**RE: Luther Burbank Waterfront Improvements Project
(SHL22-023, SHL22-024, SHL22-025, CAO22-018, SEP22-019)
Request for Information 1; 2048 84th Ave SE, Mercer Island, WA 98040**

SUMMARIZED CITY PERMIT REVIEW COMMENTS - LUTHER BURBANK WATERFRONT IMPROVEMENTS

DRAWN: AS	PROJECT NO.: 2200248
DESIGN: SS	SCALE: 1" = 20'
CHECKED: NAW	DATE: 10/07/2022
DRAWING NO.	G-020
SHEET NO.	05 of 56

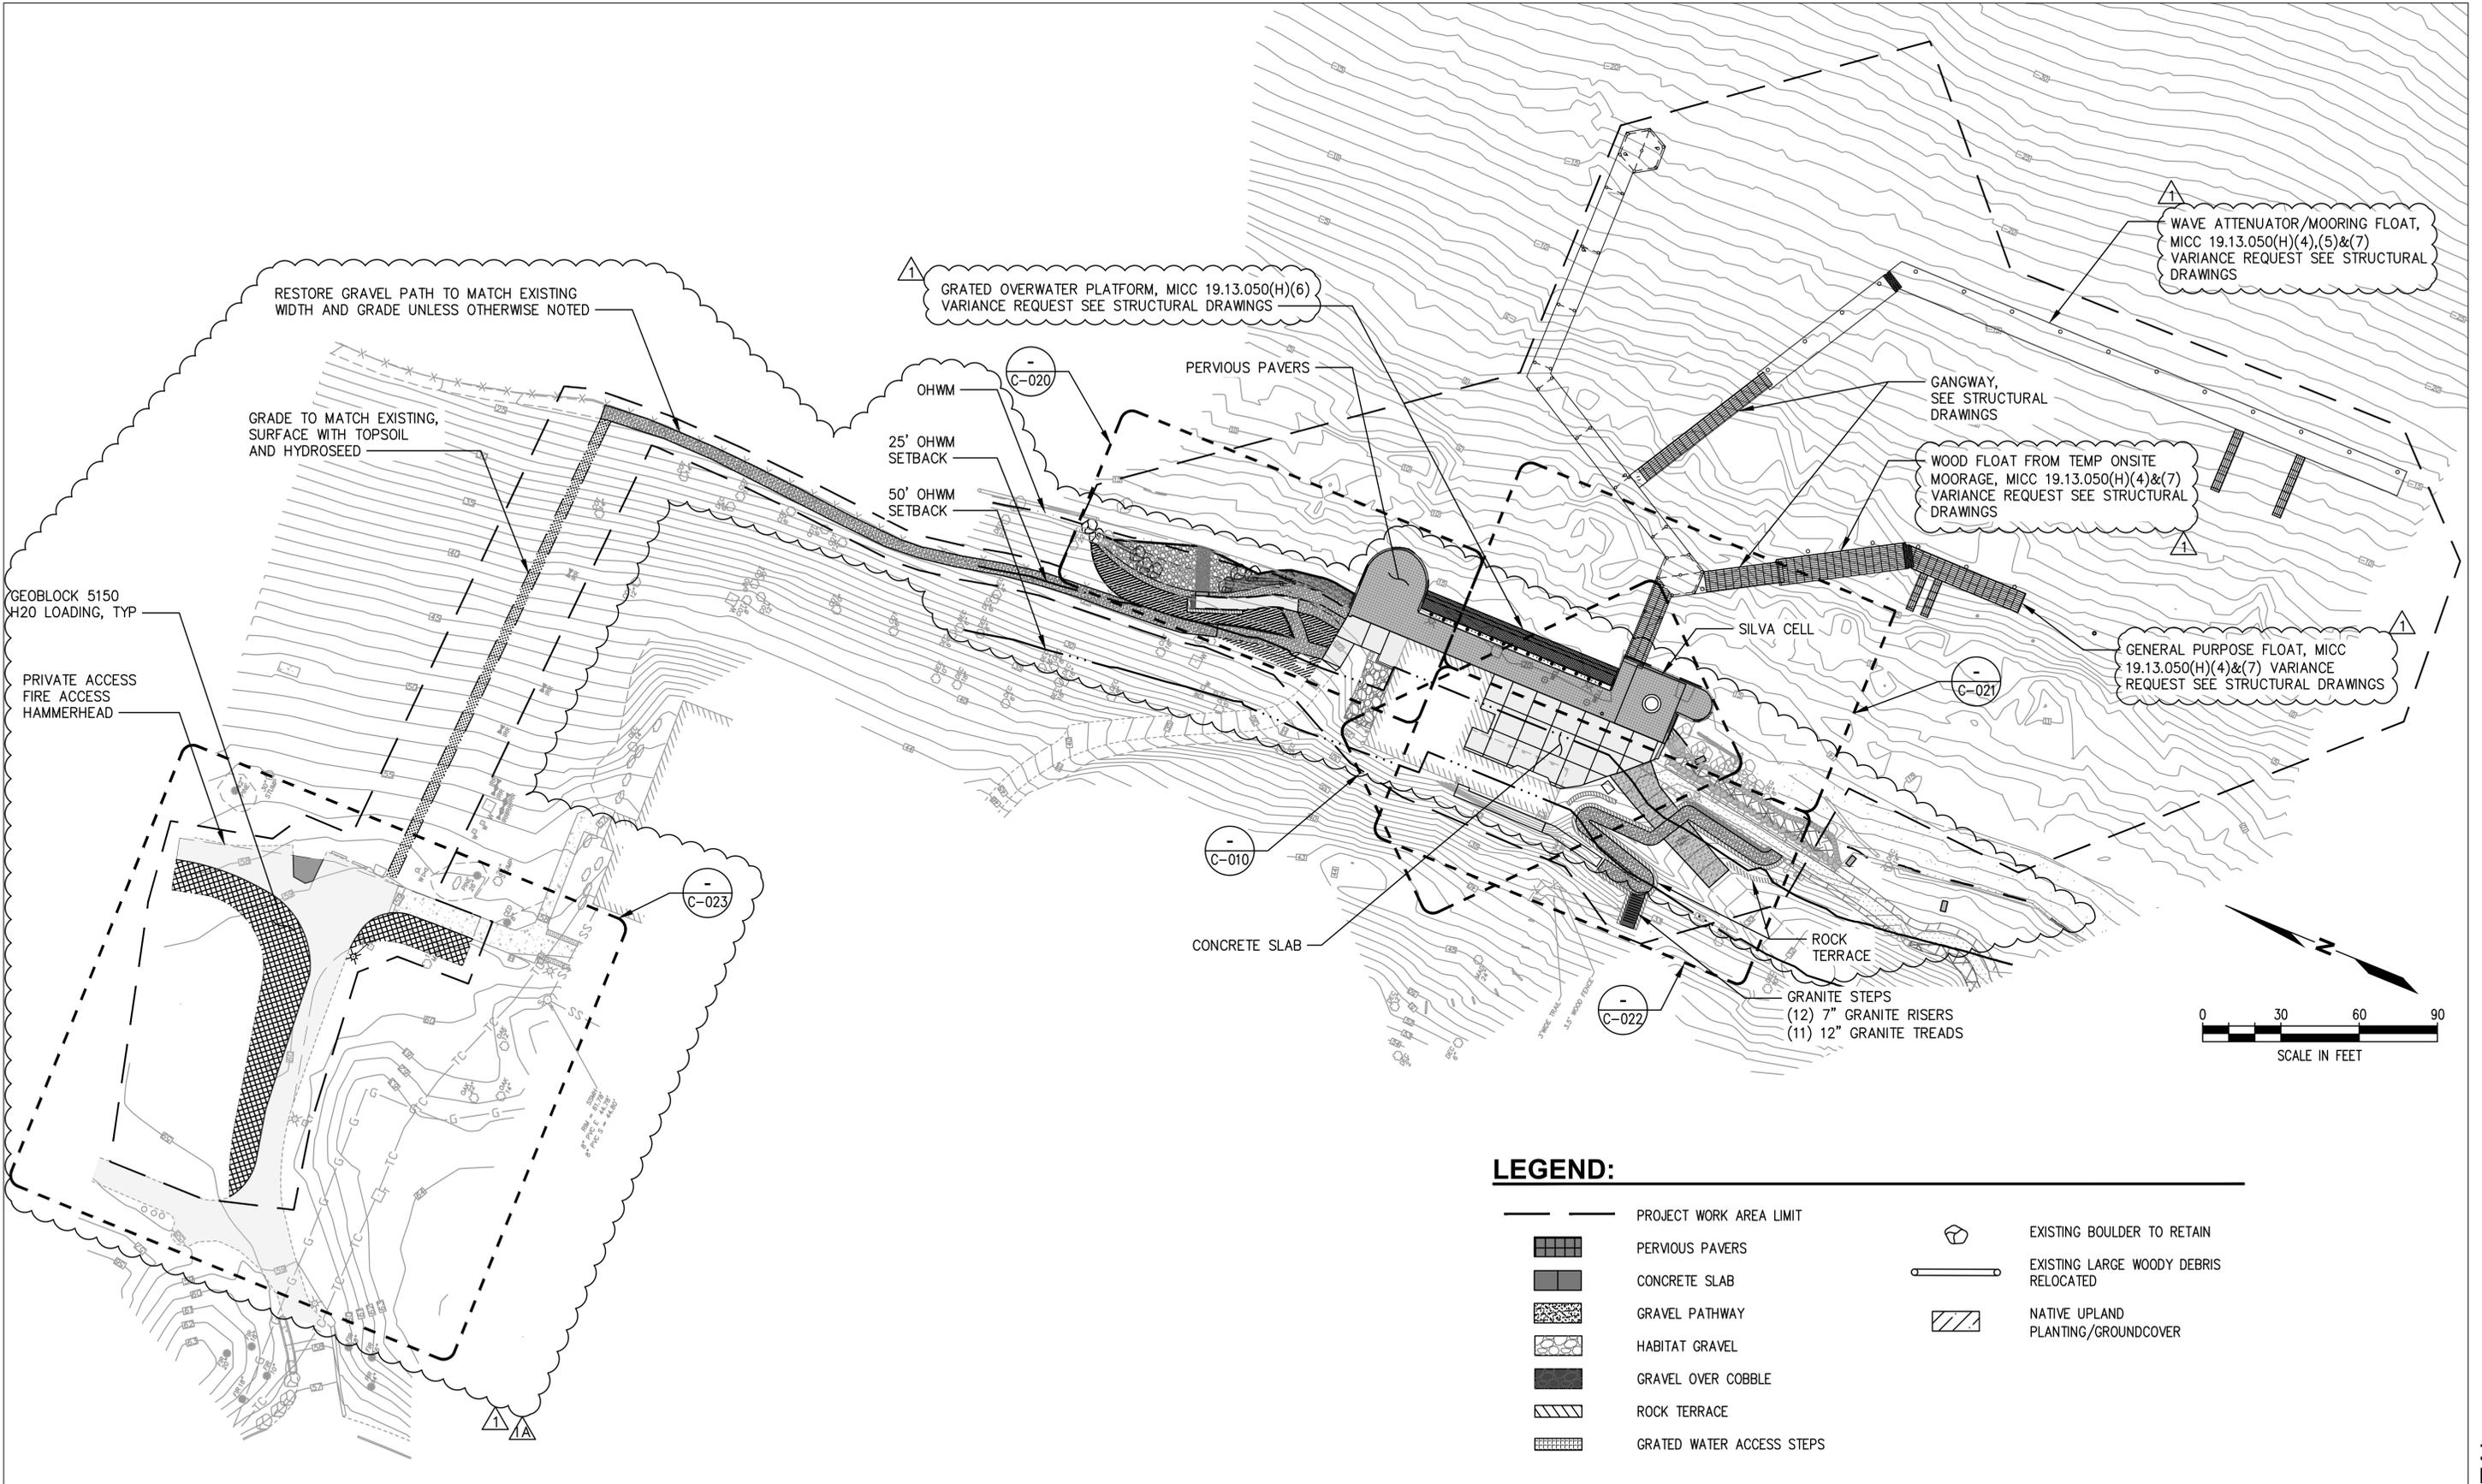
| ITEM NO. | DWG. NO. | Comment | Code | Response | Resolved? |
|----------|----------|--|------|--|-----------|
| 3 | G-020 | <p>Provide a Shoreline Code Compliance Table demonstrating compliance with MICC 19.13.050(D) Table D.</p> <p>Include information for each in-water and overwater structure.</p> | A | Shoreline Code Compliance Table exists in the permitting documents. | |
| 4 | G-020 | Provide a Shoreline Code Compliance Table demonstrating compliance with MICC 19.13.050(A) Table C and update plans with applicable information | A | JJ update: Shoreline code compliance table has been added to the shoreline permit application. | |
| 5 | G-020 | <p>Provide table showing compliance with lot coverage and hardscape limits within 0-25 (10%) & 25-50 (30%) ft from the OHWM</p> <p>Show lines 25 and 50 ft from OHWM</p> | A | Setback limit lines added to the plan sheet. | |
| 6 | G-020 | Provide a Shoreline Code Compliance Table demonstrating compliance with MICC 19.13.050(H) for public access piers, docks, and boardwalks. | | JJ update: Shoreline code compliance table has been added to the shoreline permit application. | |

| ITEM NO. | DWG. NO. | Comment | Code | Response | Resolved? |
|----------|----------|---|------|---|-----------|
| 7 | G-020 | <p>Provide description of the boiler building nonconformity and proposed alteration (stack height and setbacks) per MICC 19.13.020(A)</p> <p>Include approximate date of construction for the building.</p> | A | <p>Setbacks The basic setback is 25 feet. The boiler building is located on the lakeshore, and was constructed in 1928. Its east wall is located approximately 13 feet west of the concrete bulkhead which is the shore of Lake Washington. The 1974 addition was constructed approximately 36 feet west of the concrete bulkhead, which is the shore of Lake Washington. The proposed new roof deck is located on top of the existing 1974 addition, and will be the same 36 feet west of the concrete bulkhead.</p> <p>Shoreland Uses Public Parks and Open Space are permitted outright.</p> <p>Height Limits The basic height limit is 35 feet. The boiler building tower is approximately 80 feet above average building elevation. The project proposes removing approximately 8 feet from the top of the tower, as a seismic mitigation strategy that balances the weight of the tower, the existing foundations, and structural support. The new height of the building tower will be approximately 72 feet. The boiler building main structure is approximately 24 feet above average building elevation.</p> <p>The boiler building was constructed in 1928. The addition, which contains men's & women's toilet rooms and concessions, was constructed in 1974.</p> | |
| 8 | G-020 | Call out elements where variances and SCUP are requested | A | Elements with variances and SCUP have been identified. | |
| 9 | G-020 | Show OHWM | A | OHWM extended north and south. | |
| 10 | G-020 | What are the specifics of the dock grating variance request? How much of the dock will be grated with 40% light transmittance? | A | <p>Comment is attached to general purpose float which is fully grated with 40% minimum light transmittance as noted on drawing S-050.</p> <p>Dock grating variance request pertains to central wave attenuator/mooring float. In order to protect shoreline ecological functions and provide safe use and programming for the south dock, the central float sections will not transmit light. Float is located as far off shore as practical (closest point is 115 feet from OHWM) in approximately 36 to 38 feet of water to minimize effect of shading on the lake bottom.</p> | |
| 11 | G-020 | <p>Per MICC 19.13.040 - Table B, breakwaters, jetties, and groins are not permitted unless for restoration of ecological function. A wave attenuator is a breakwater based on the definition in MICC 19.16 and the description of the purpose of the central dock design.</p> <p>Provide more information.</p> <p>Include demonstration of compliance with MICC 19.13.050(G) for restoration or protection of critical areas if applicable.</p> | A | Added to Shoreline Permit narrative. | |

| ITEM NO. | DWG. NO. | Comment | Code | Response | Resolved? |
|----------|----------|--|------|---|-----------|
| 12 | G-020 | Include a drawing to show property lines and 10 ft lateral line setback to show compliance with MICC 19.13.050(D) | D | See "Buoy Plan" on S-010. Site of improvements are located within the middle portion of the park shoreline, over 600 ft from the nearest private property lateral line. | |

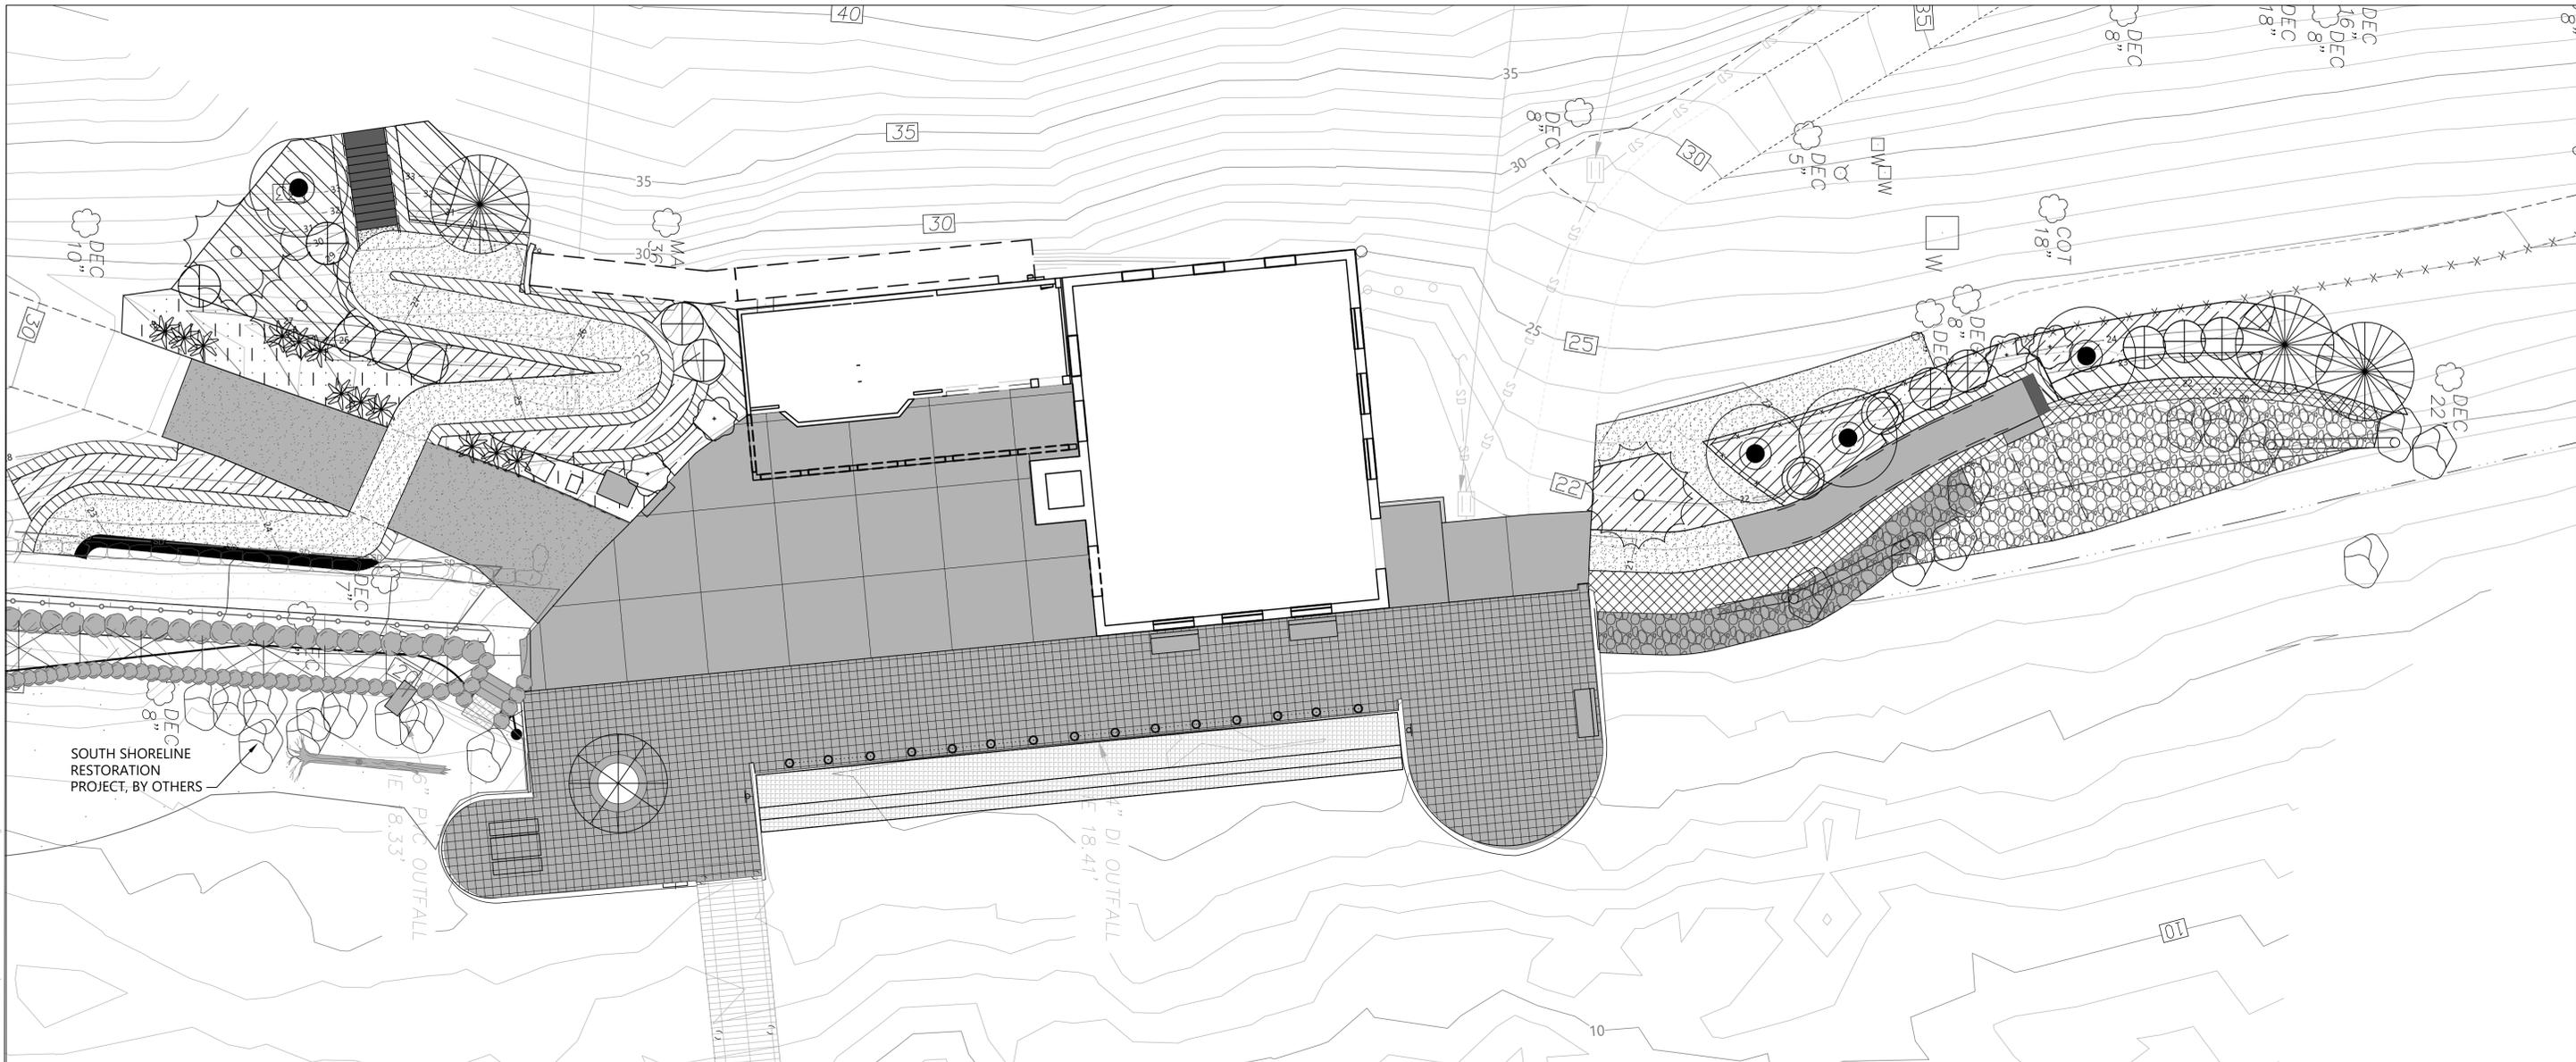
| ITEM NO. | DWG. NO. | Comment | Code | Response | Resolved? |
|----------|----------|--|------|---|-----------|
| 15 | CM-014 | Please indicate the design function for this rock revetment and how the installation complies with the requirements of MICC 19.13.050.(B). | A | MICC 19.13.050(B) allows for new structural stabilization measures to be installed that "protect projects for the restoration of ecological functions." The proposed shoreline stabilization measures will protect the proposed accessible public access trail and restoration areas located landward of the beach. The Rock revetment wall is located above the OHWM and does not encroach waterward of the OHWM. This wall functions to provide shoreline stabilization to support the pedestrian access to the beach and will absorb wake energy to reduce the risk of erosion at this location. Invasive species will be removed and the upland area will be replanted with native riparian planting. The existing beach habitat gravels and log will be temporarily removed for construction then replaced after the rock revetment wall is installed abutting these existing features, above the OHWM. This feature will assure no net loss of ecological function and will allow public access to an enlarged beach area. The enlarged beach area is designed to increase ecological function for salmonids. | |
